# KIRKLEES METROPOLITAN COUNCIL INVESTMENT & REGENERATION SERVICE

Reference No:	<b>2024/70/92395/W</b>
Site Address:	Former Kirklees College, New North Road, Huddersfield, HD1 5NN
Description:	Variation of condition 2 (plans and specifications) and 3 (phasing) of previous permission 2023/93058 for variation of conditions 2 (plans), 3 (phasing plan) of previous hybrid permission 2018/92647 for mixed use development - retail/office and 229 residential units (Use Classes C3/ E(a) /B1a); full planning permission for partial demolition of former Kirklees College; erection of food retail store and alterations in connection with conversion of grade ii* listed building to offices/apartments; creation of vehicular access from Portland Street, New North Road and Trinity Street; outline application for erection of (two) buildings (residential apartments - C3 Use ) (Listed Building within a Conservation Area)
Recommending Officer:	Victor Grayson

**Application:** 2024/92395

**Site:** Former Kirklees College, New North Road, Huddersfield

Proj Ref	Origin	Zone	Level	Type	Rate	Norm	Status	Rev
7355 - SMR - 00 - XX - DR - A - 2005 - S3 - C2								
SMR Job Ref	Sheet	Scale	Drawn	Rev				
7355-00-2005	A0	As indicated	SM

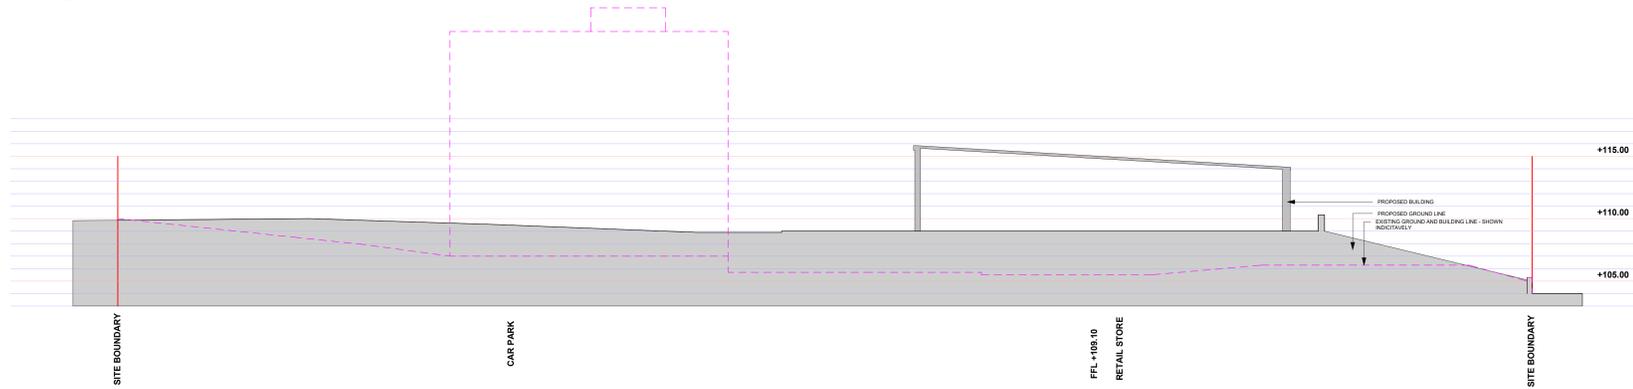
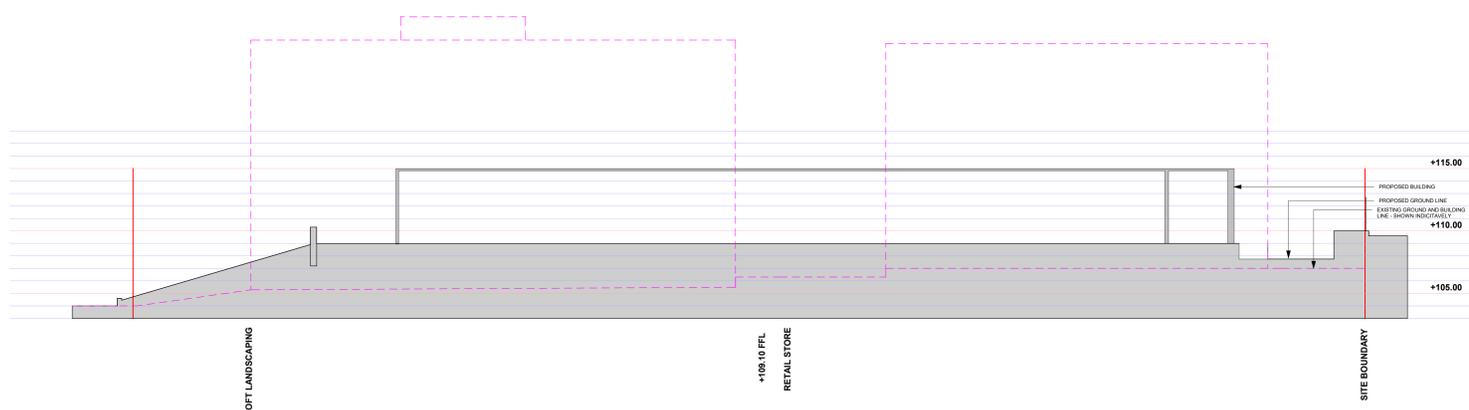
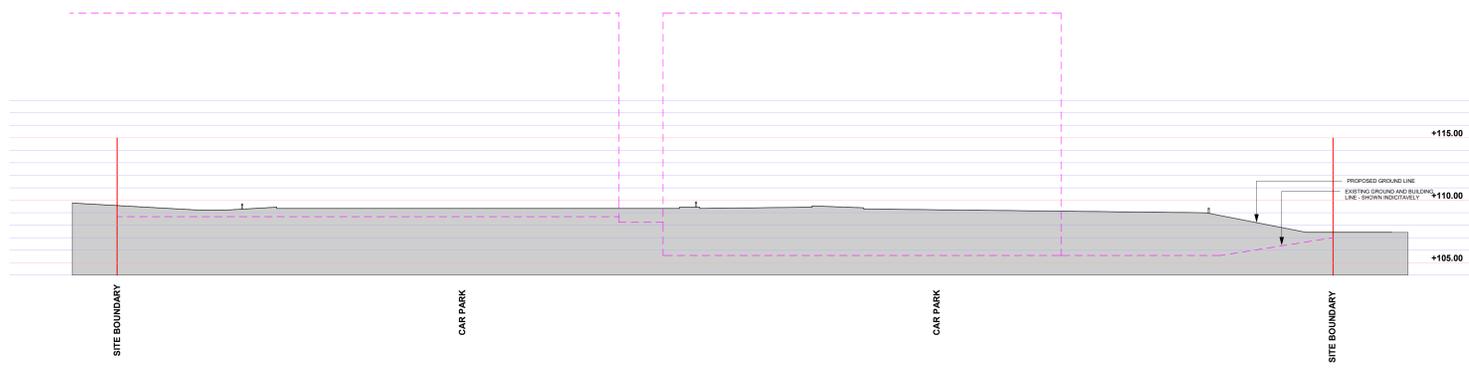
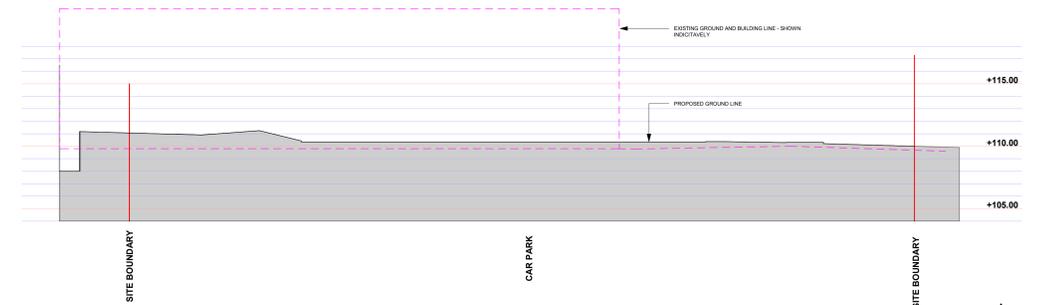
For the retail food store, the submitted drawings show a hipped “crown” roof and a canopied entrance feature supported by columns (similar to what has been erected at Lidl’s Holmfirth site, and to what has been granted planning permission at Lidl’s Oakes site). An earlier iteration of these design features was proposed via the applicant team’s email of 11/05/2021 and was considered under application 2018/92647 (as briefly noted in the committee report of 24/02/2022 at paragraph 3.6), and the decision notice for application 2018/92647 accordingly listed a “Building Elevations” drawing (ref: 7355-00-8101 rev P7). However, the decision notice for application 2018/92647 also listed drawings 2102, 2103, 007 and 2005, which all showed an earlier mono-pitched roof that was previously proposed for the Lidl store. This was an error, and the error was repeated in the decision notice for application 2023/93058. It is also noted that two of the section drawings submitted under this current Section 73 application (namely, Proposed Site Sections (drawing 00-007 rev F) and Site Sections (drawing 7355-SMR-00-XX-DR-A-2005-S3 rev C2)) also show the outline of a mono-pitched roof for the Lidl store.

An informative (to be included in the council's decision notice for this application) is recommended, noting that two section drawings still indicatively show the outline of a mono-pitched roof, but that such a roof form is not approved for the retail food store.

For the avoidance of doubt, moving away from a mono-pitched design to a design that includes a hipped roof and a canopied entrance feature supported by columns is considered acceptable. The proposed hipped roof shape would be more reflective of the roofs of surrounding buildings (when compared with the previously-approved mono-pitched roof). The canopied entrance feature supported by columns would add visual interest, would help mark the site's entrance and could make it more legible to customers. Appropriate "reveal details" are proposed in the elevations, which would add interest to what would otherwise be long, unrelieved elevations. An appropriate dentil cornice detail is shown beneath the proposed eaves. Although there remains scope for further improvement to the design of the retail food store, the design features now proposed have proved successful at Lidl's Holmfirth site, where a relatively new retail food store has responded appropriately to its context which is dominated by older buildings.

Proj Ref	Origin	Zone	Level	Type	Role	Num	Status	Rev
7355 - SMR	- 00	- ZZ	- DR	- A	- 2003	- S4	- C2	
SMR Job Ref	Sheet	Scale	Drawn					
7355-00-2003	A2	1: 500	SM

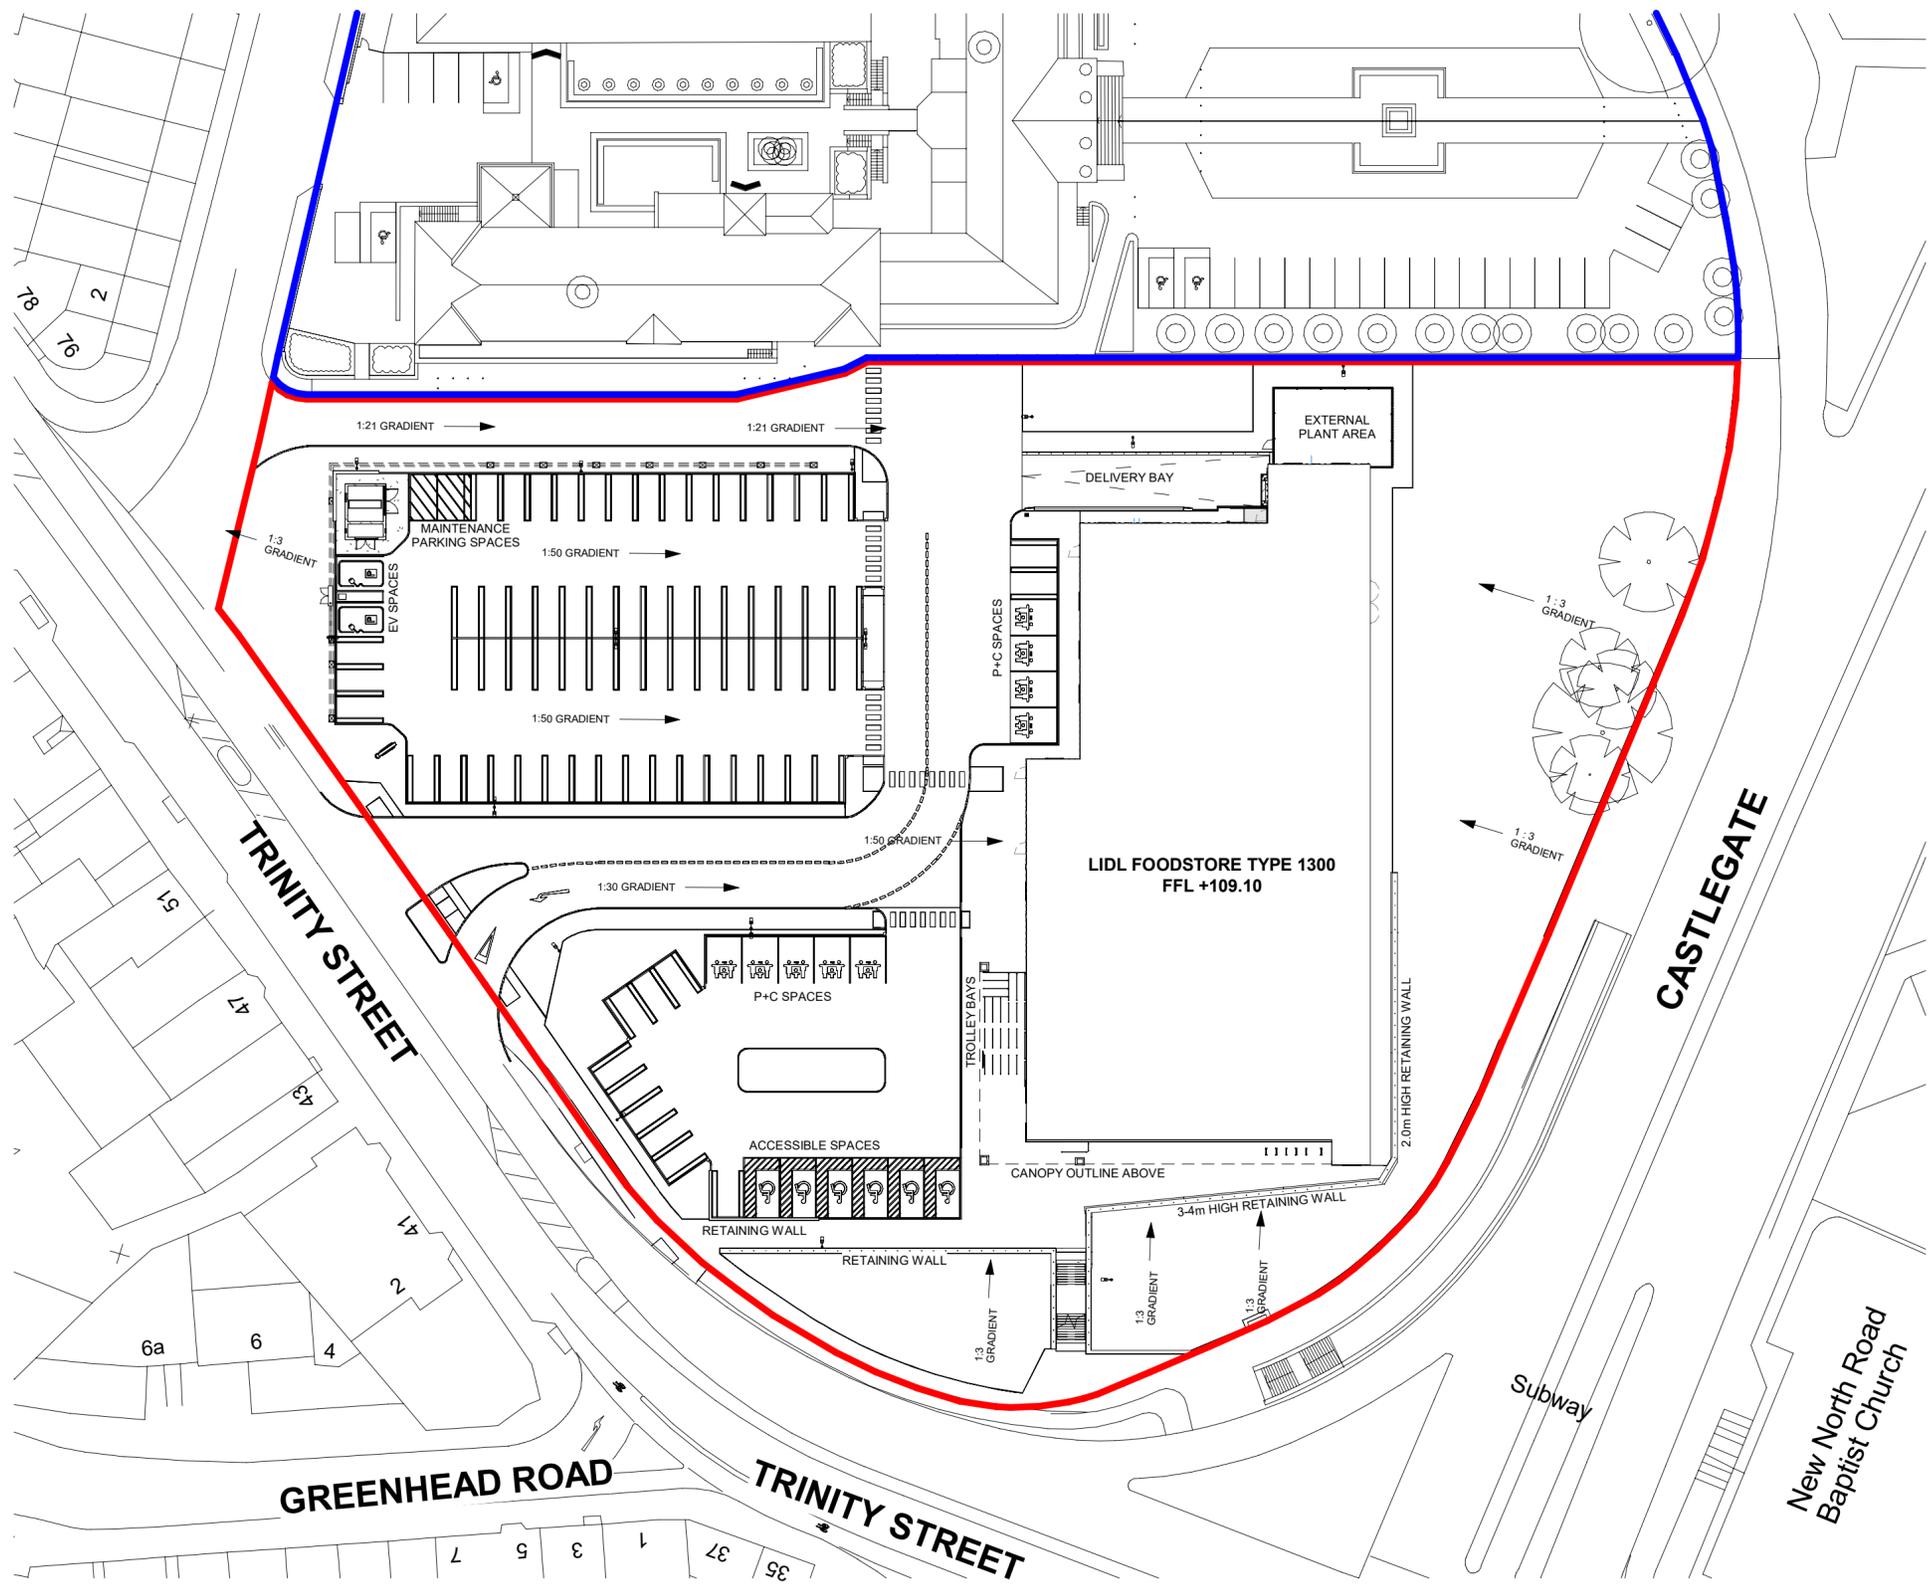
Changes to the car park of the retail food store (including a reduction in the number of parking spaces) were shown on the submitted site plan but were

not described in the covering letter of 06/08/2024. These changes were queried with the applicant's agent, who responded on 26/11/2024 and confirmed:

*The southern part of the parking layout has been amended to incorporate more parent-child and in order to move the accessible spaces in line with the new store footprint.*

*Two EVC spaces have also been introduced in the northern part of the car park, and the substation area has also been slightly enlarged.*

*The pedestrian crossings have also been amended to suit the amended layout operations".*

KC Highways Development Management (HDM) have reviewed the proposed changes to the car park. Although Lidl's own guidance states that stores of this size should provide over 100 car parking spaces, on balance HDM accept the proposed reduction in on-site car parking, given the proposed spaces would be more accessible (being bigger than standard bays) which would improve the efficiency of vehicular movements internally, and given that the site is located in a fairly sustainable location on the edge of the town centre.

Given the above assessment, the proposed changes are considered acceptable in highway terms.

1 FRONT ELEVATION  
1 : 200

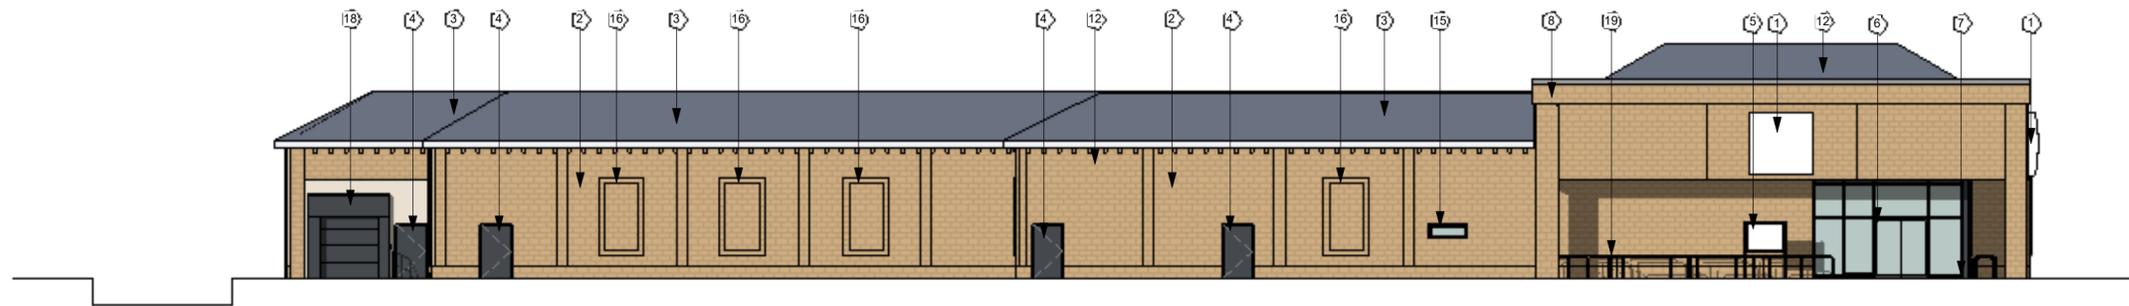
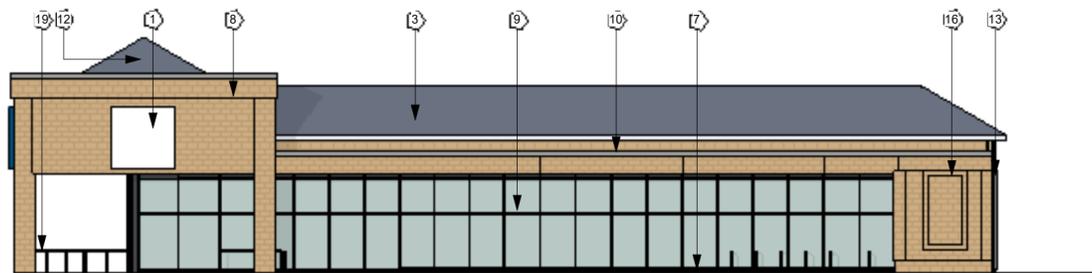
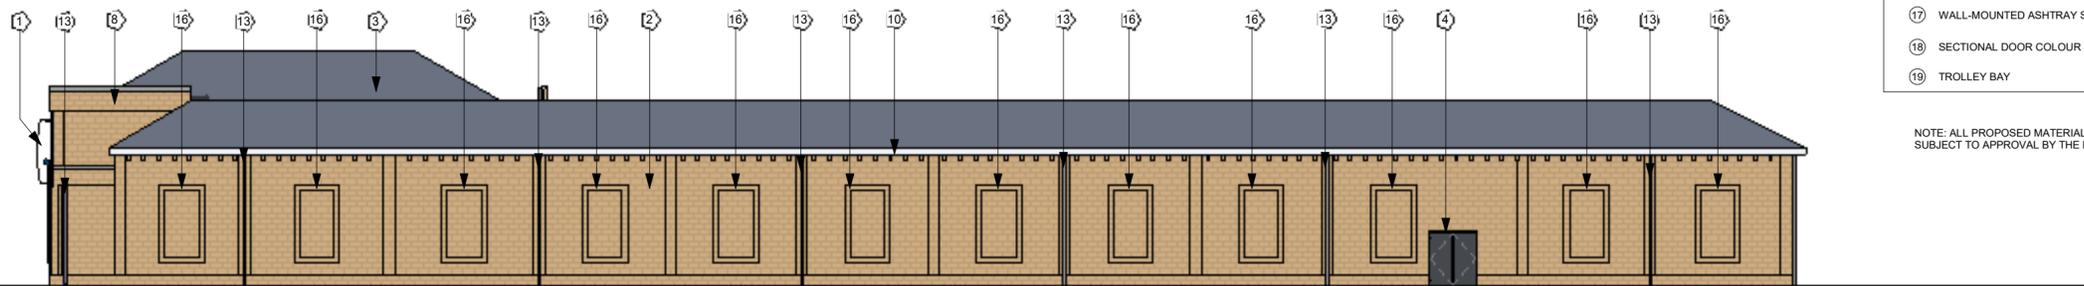
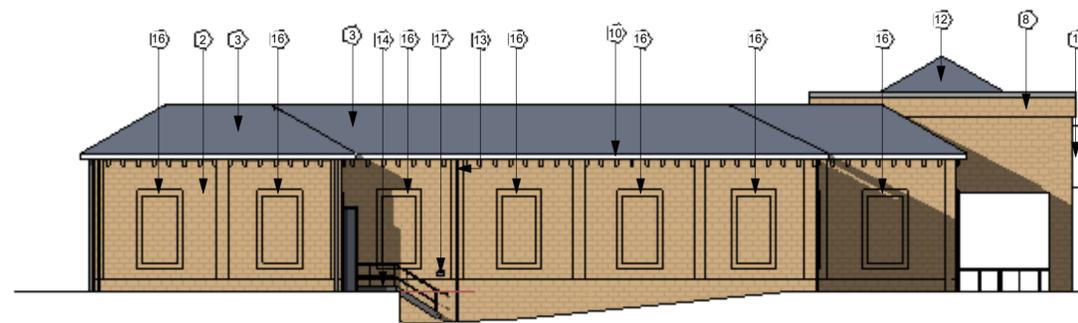
The proposed changes to the footprint shape of the retail food store would involve an increase in its width (measured east-west) and a decrease in its length (measured north-south). The attached plant enclosure would be moved from the east elevation to the north elevation. The delivery bay at the north end of the building would be moved southwards, away from the listed buildings within the wider site.

The retail food store's south elevation would be wider than that previously approved. This elevation would still be predominantly glazed, which could add interest to (and would potentially activate) the building's most prominent and frequently-seen elevation, if the glazing is not covered with vinyl graphics or otherwise obscured.

The use of carefully-chosen materials remains essential at this site. Under permission 2018/92647, drawing annotations referred to natural stone for the retail food store's elevations, and the committee report referred to blue slates for the crown roof. In the current proposals, a "stone face finish" is annotated for the elevations – this is considered acceptable, subject to full details and samples being submitted and approved at conditions stage. For the roof, "blue tiles" are annotated in the current proposals – this is unlikely to be as appropriate as natural slate, however further consideration of roofing materials would be necessary at conditions stage. Of note, a "slate tiled roof" was annotated on drawing P201 rev G submitted under application 2021/94029 for Lidl's Oakes site.

Viewport 1: HGV Service Yard Access

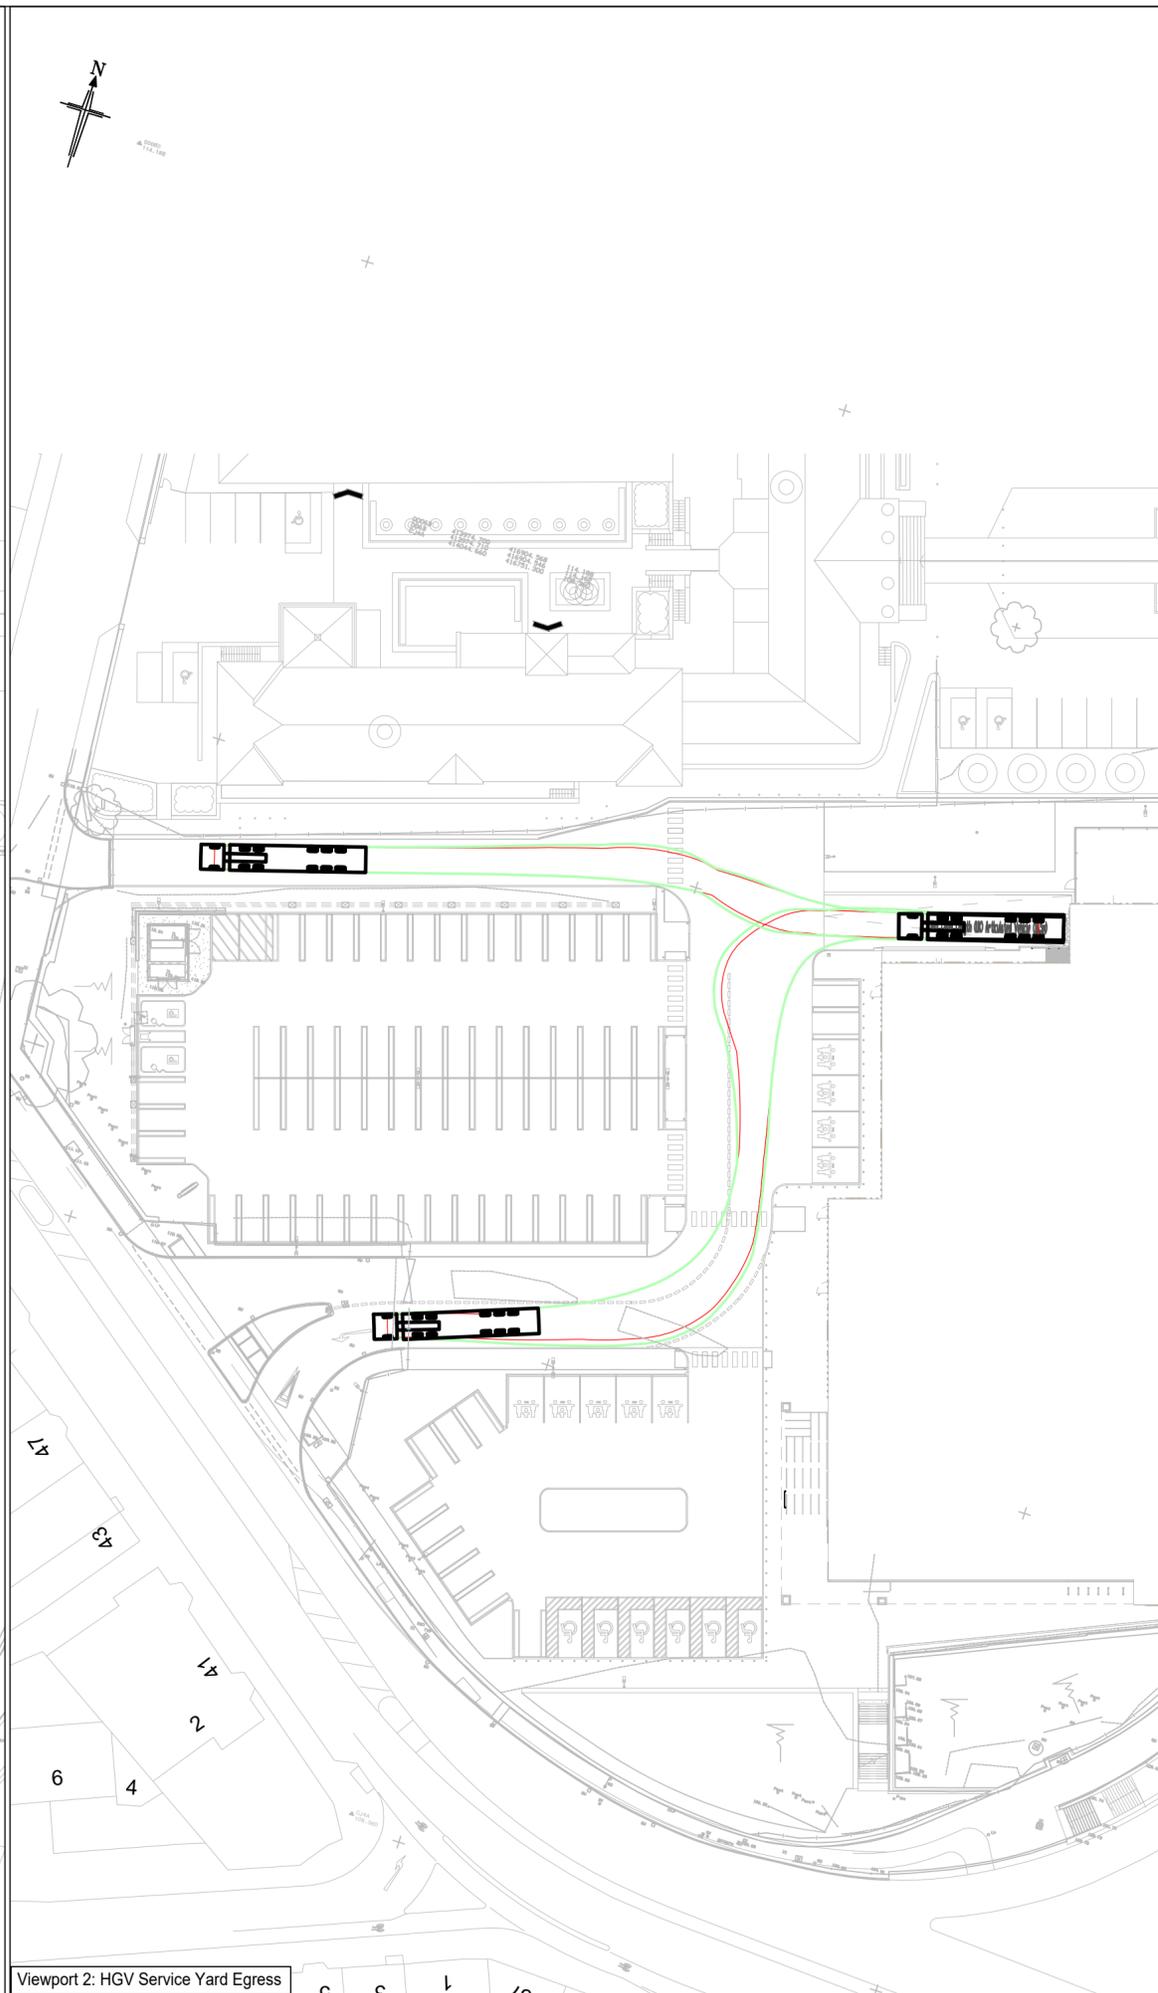
In addition, on 26/11/2024 the applicant's agent submitted swept path analysis drawing, illustrating movements of an HGV within the reconfigured car park.

The applicant's swept path analysis drawing demonstrates that a 16.5m long articulated vehicle would be able to access the retail food store's delivery bay via the proposed reconfigured car park.
